PLANNING AMENDMENT

H18/1119/94

REAR OF FORMER INFANT SCHOOL, SUTTON BRIDGE, SPALDING, Lincs

TEMPORARY SITING OF RESIDENTIAL
CARAVAN FOR A PERIOD OF TWO YEARS
DURING CONSTRUCTION OF PERMANENT
DWELLING AS PER APPLICATION
REF: H18/1009/94

project no. drawing no.
1301 AL/1

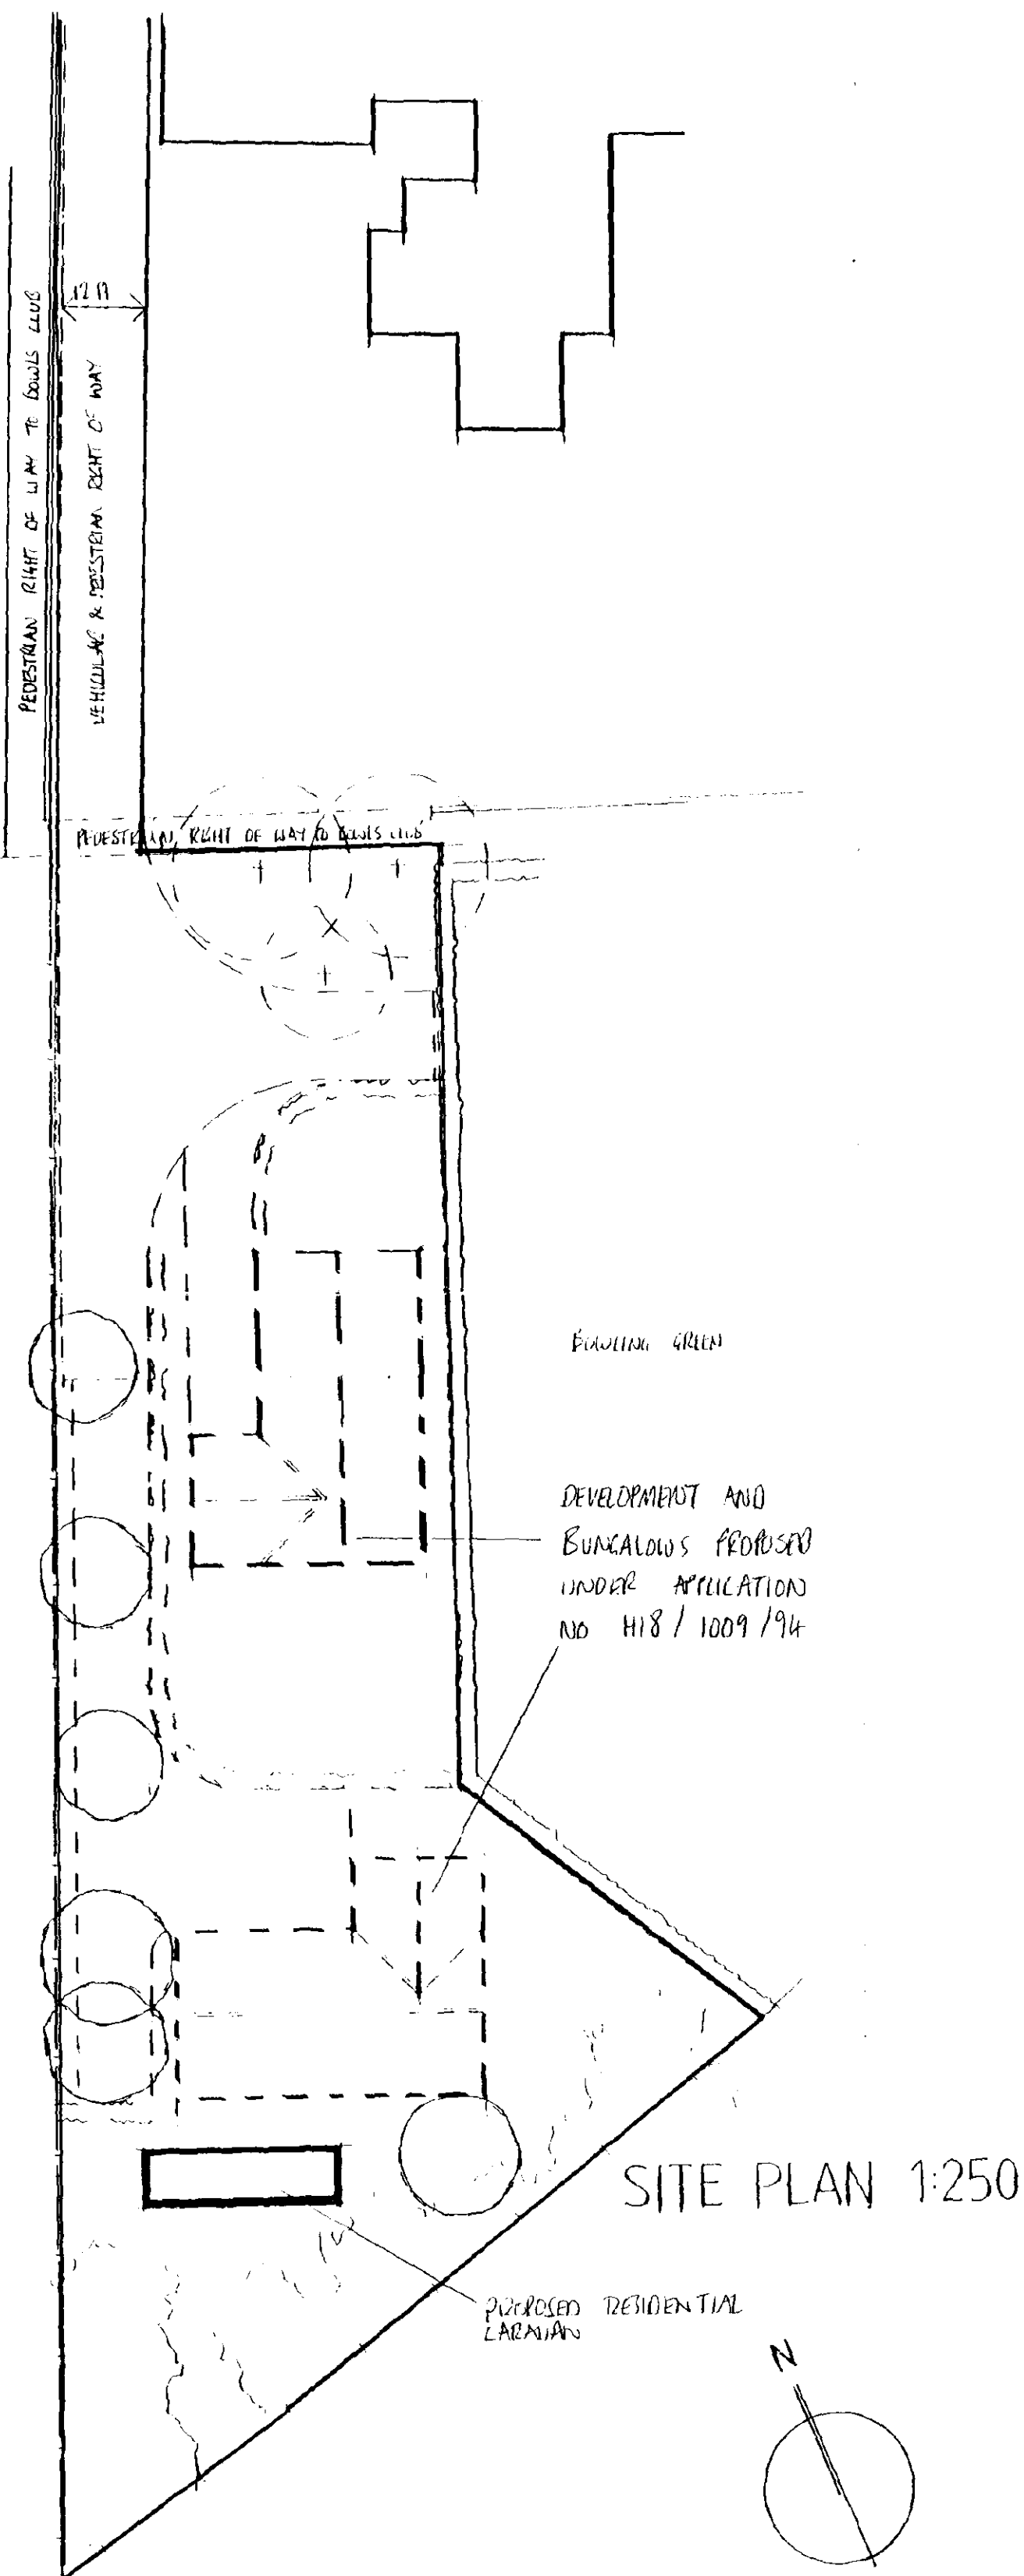
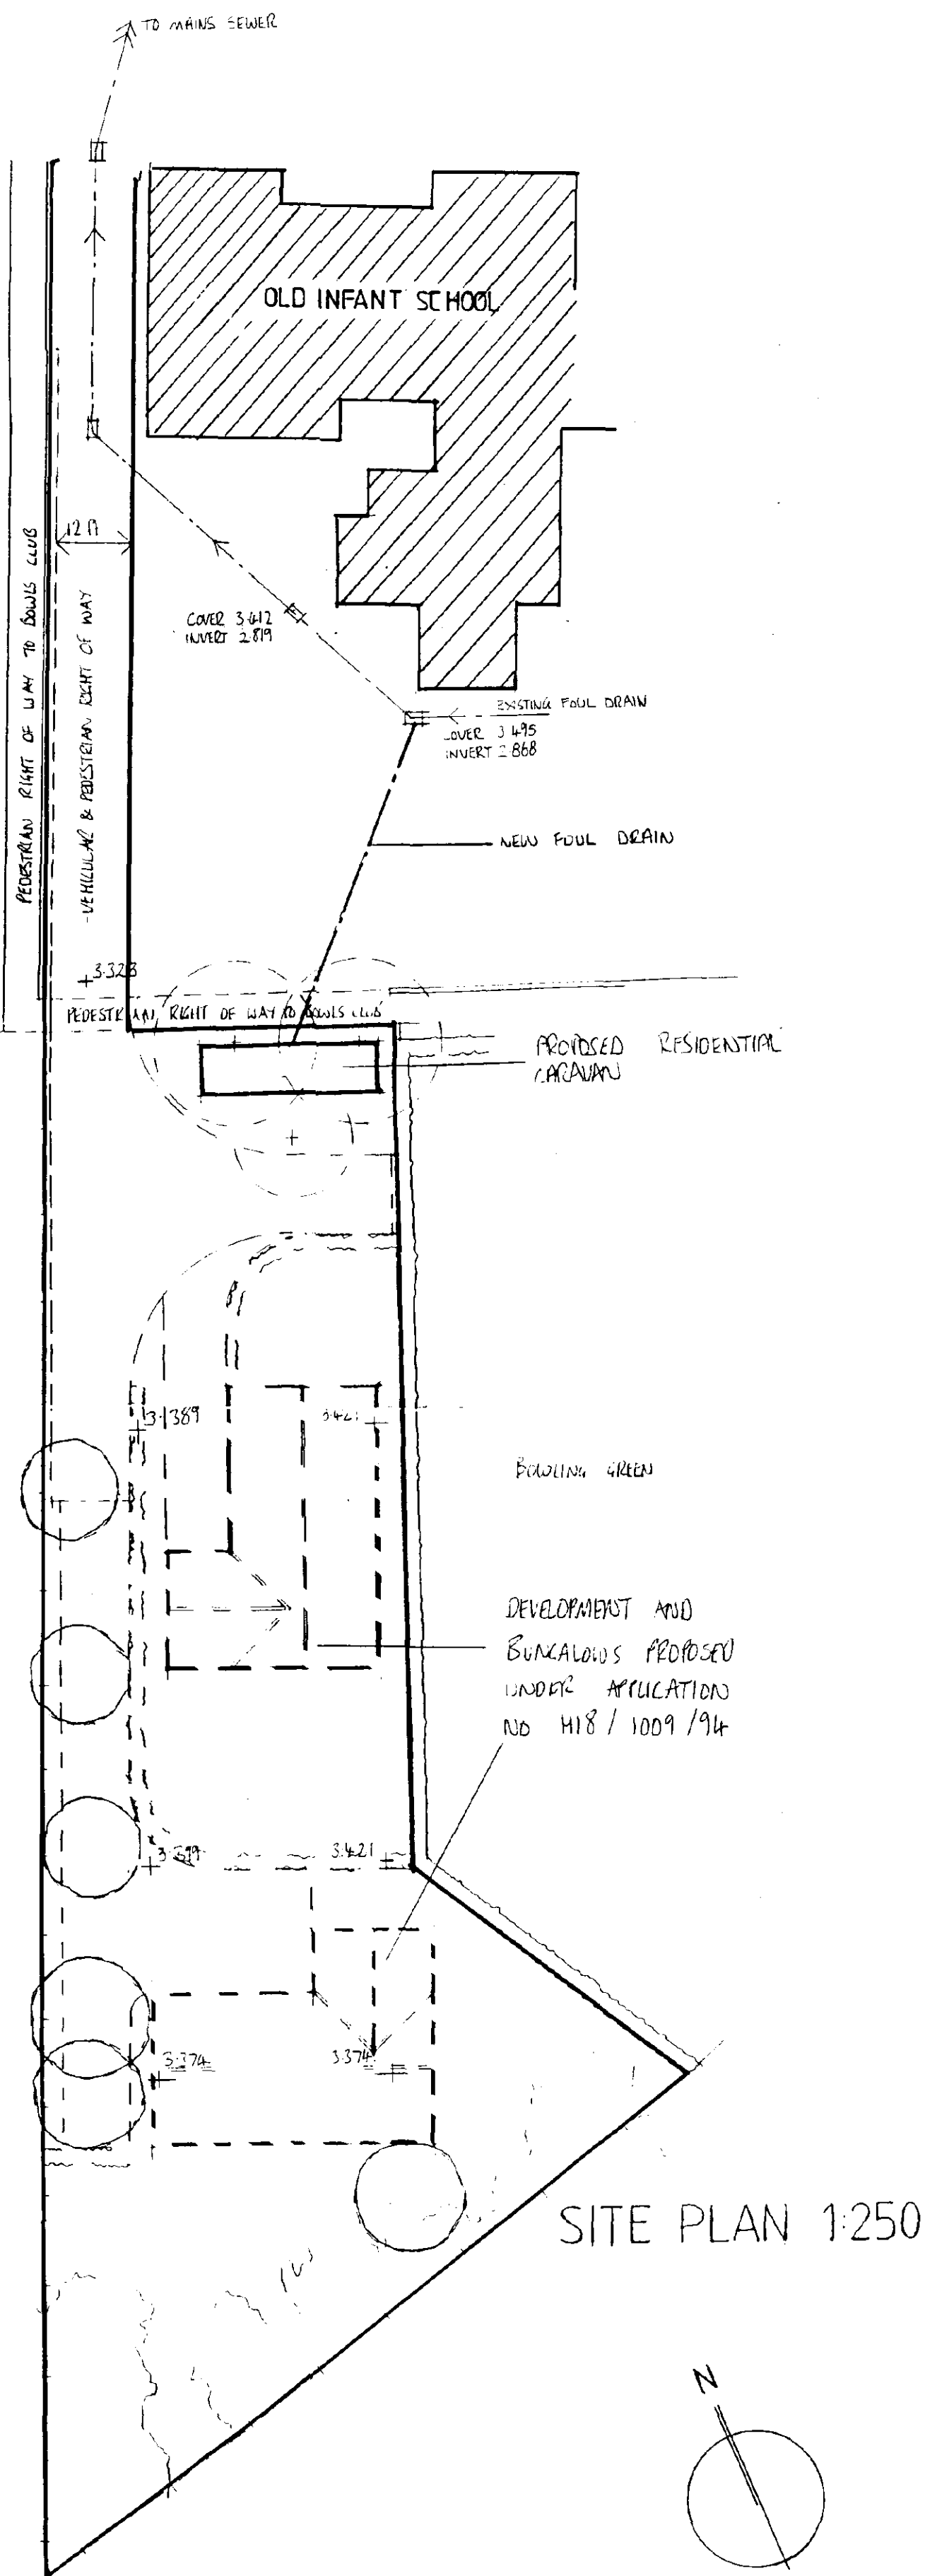
AMENDMENT OF SITING OF CARAVAN FROM
REAR OF SITE TO FRONT OF SITE TO
REDUCE LENGTH OF CONNECTIONS FOR
TEMPORARY SERVICES.

With reference to the above, our client has requested that the location of the caravan be amended in order for it to be closer for temporary services connection as indicated on the attached drawing no. 1301 AL/1 (4 no. enclosed).

The amended details submitted in respect of the above proposal have now been considered, and I am able to inform you that there are no objections to the amendment being implemented to the extent described above.
